**ExQ2: Monday 1 July**

**Application by Gatwick Airport Limited for the Gatwick Airport Northern Runway Project  
The Examining Authority's second written questions and requests for information (ExQ2)  
Issued on Monday 1 July 2024**

DRAWING TITLE
Foul Water

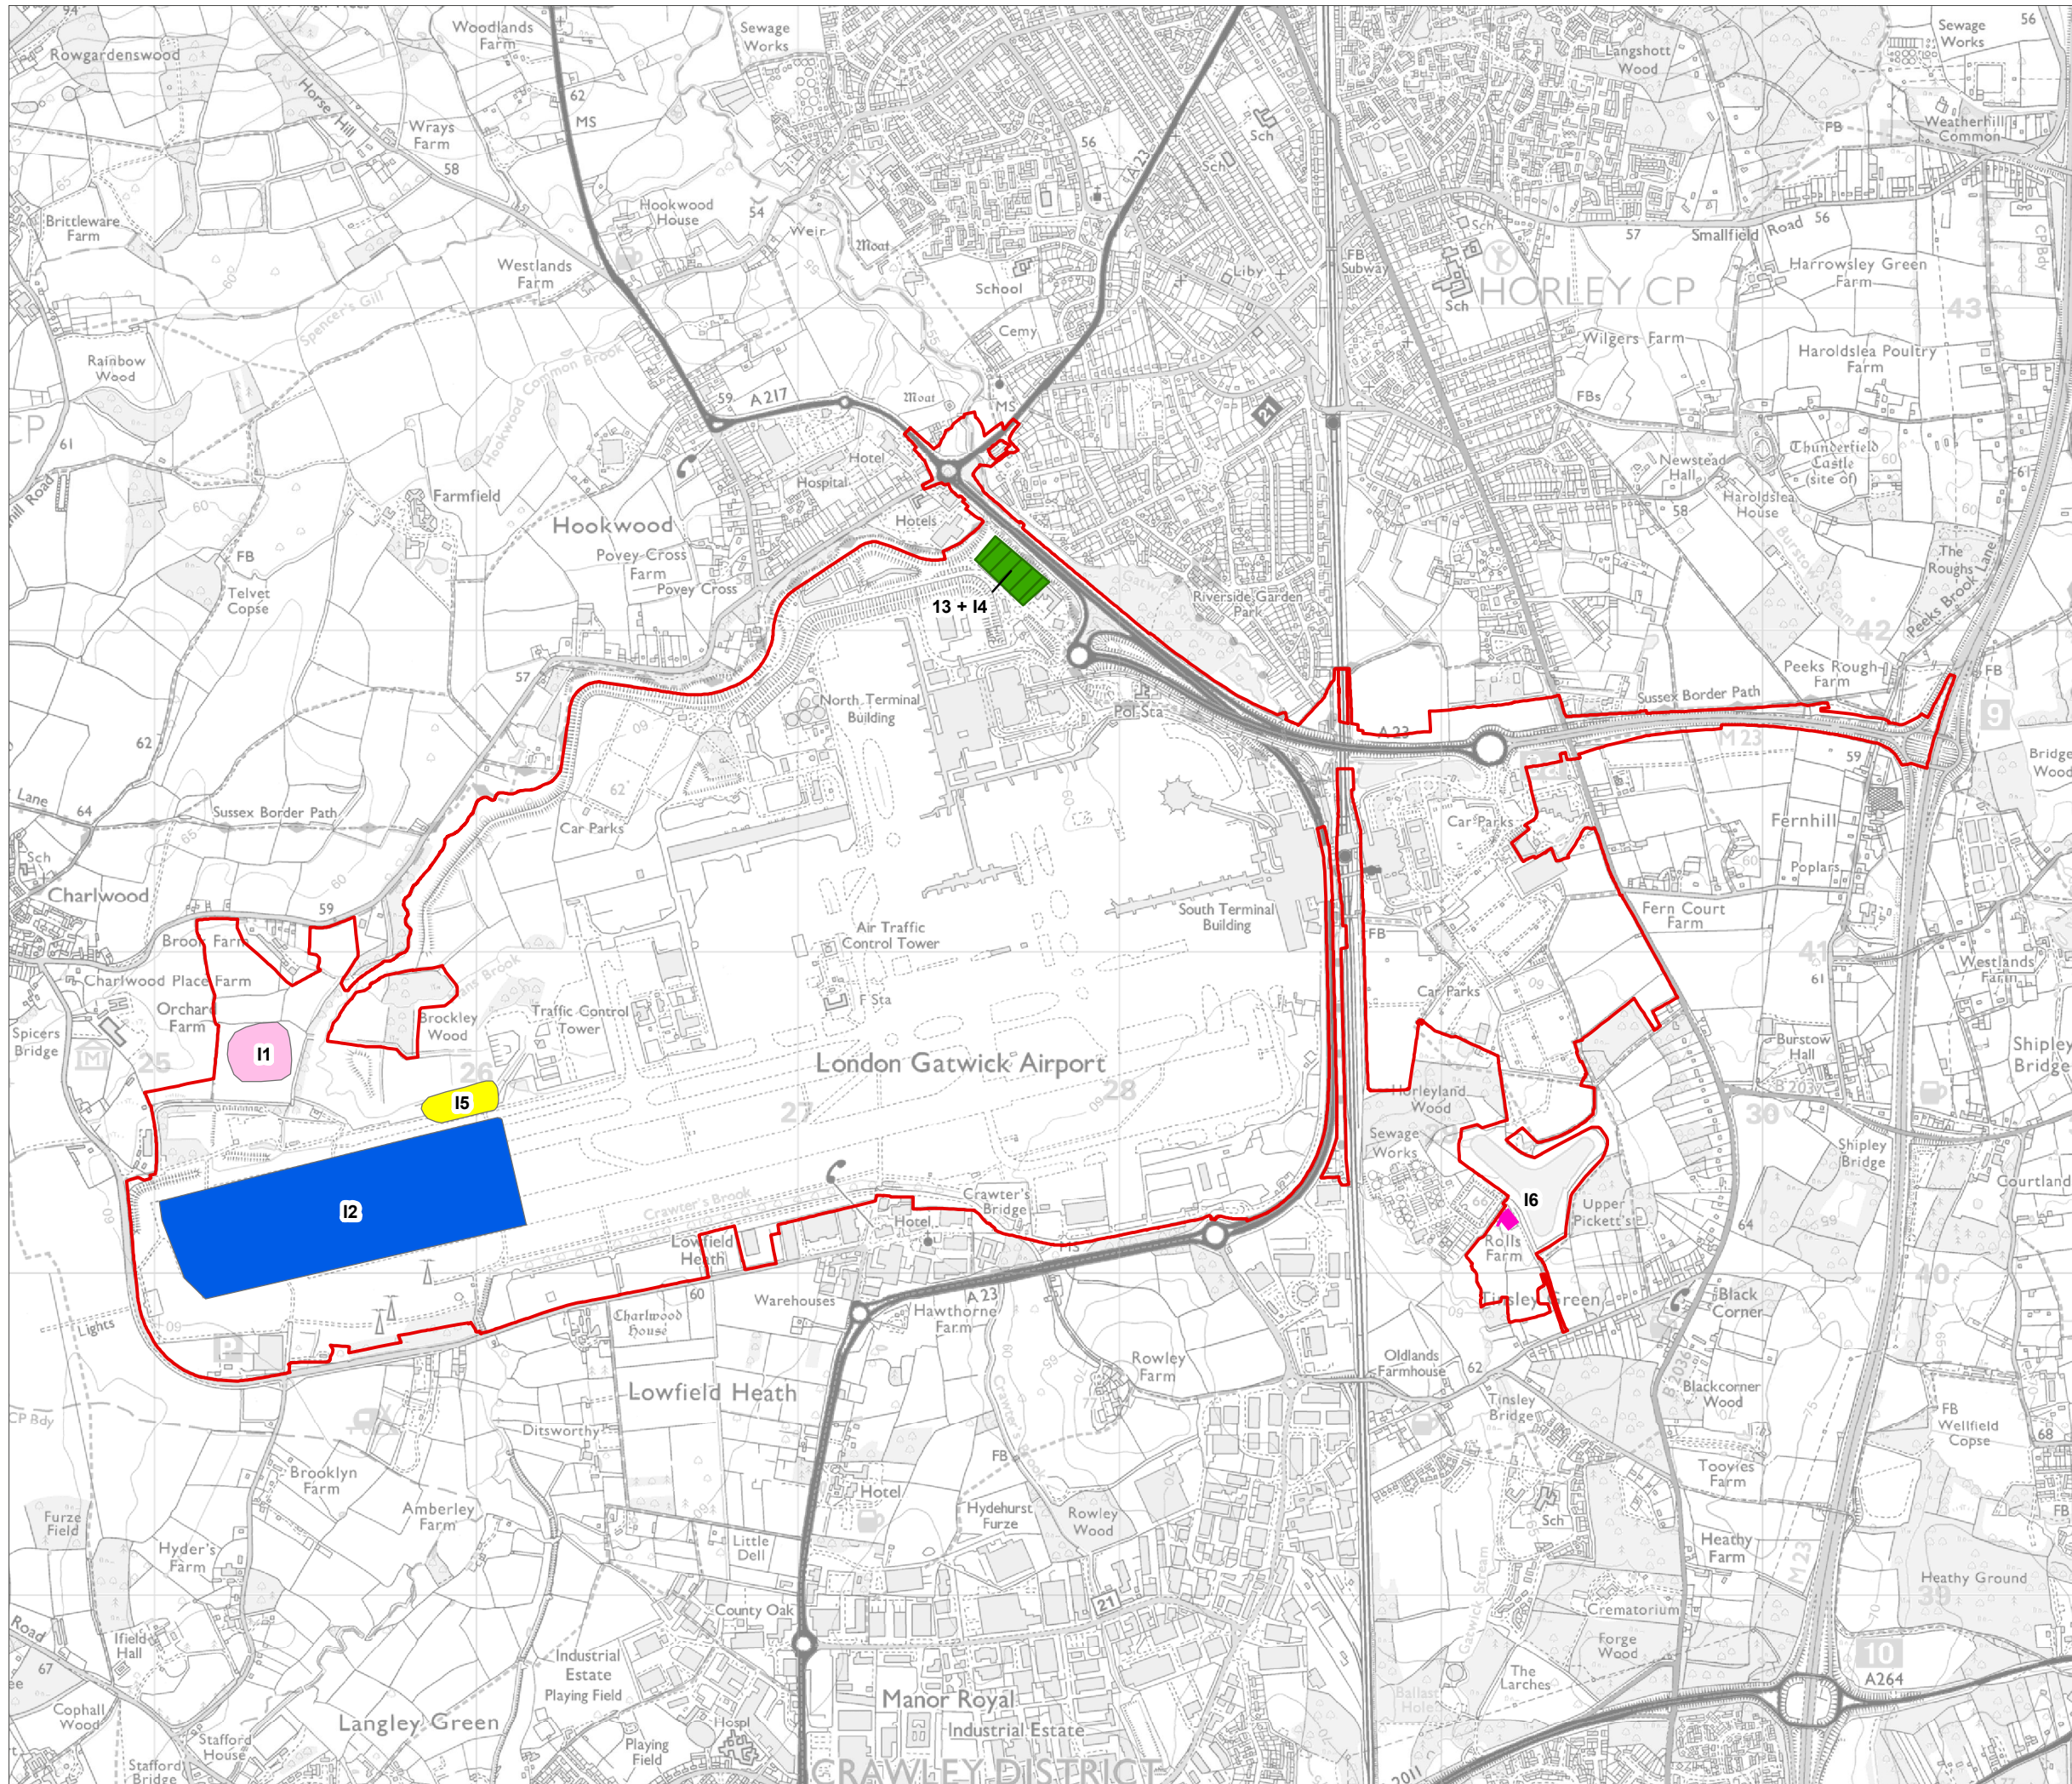
WE.2.4	Applicant Environment Agency	<p><b>Change Request – New onsite Wastewater Treatment Works</b></p> <p>The Environment Agency position as set out in the SoCG [REP5-057] in item 2.22.3.13 states that, <i>“The new treatment facility would require a bespoke environmental permit with a full assessment.”</i> It goes on to state that, <i>“The Environment Agency will not normally give you a permit for use of a private sewage treatment system based on the nearest public foul sewer not having enough capacity.”</i></p> <p>Explain whether a permit would be likely to be granted and if so would any restrictions be imposed on the permit relating to the public sewer network being upgraded.</p> <p><b>Environment Agency response:</b></p> <p>‘In principle the proposed new sewage treatment facility at Gatwick would be acceptable to us if it is operated by a sewage undertaker, i.e. a Water and Sewage Undertaker (WaSC) or a New Appointment and Variation (NAV) company. This constraint applies whether the proposed treatment is of the uplift in output arising from the development above the existing output, currently sent to foul sewer, or the full treatment of site foul sewage post development. This is because the proposed discharge is within the screening distance where we would expect a discharge to be connected to the public foul sewer in the first instance.</p> <p>Any permit application associated with this new facility would be considered by us through the permit determination process – full modelling of the proposed discharge to consider potential impacts on the receiving watercourse with appropriate permit limits set accordingly to protect the environment.’</p>
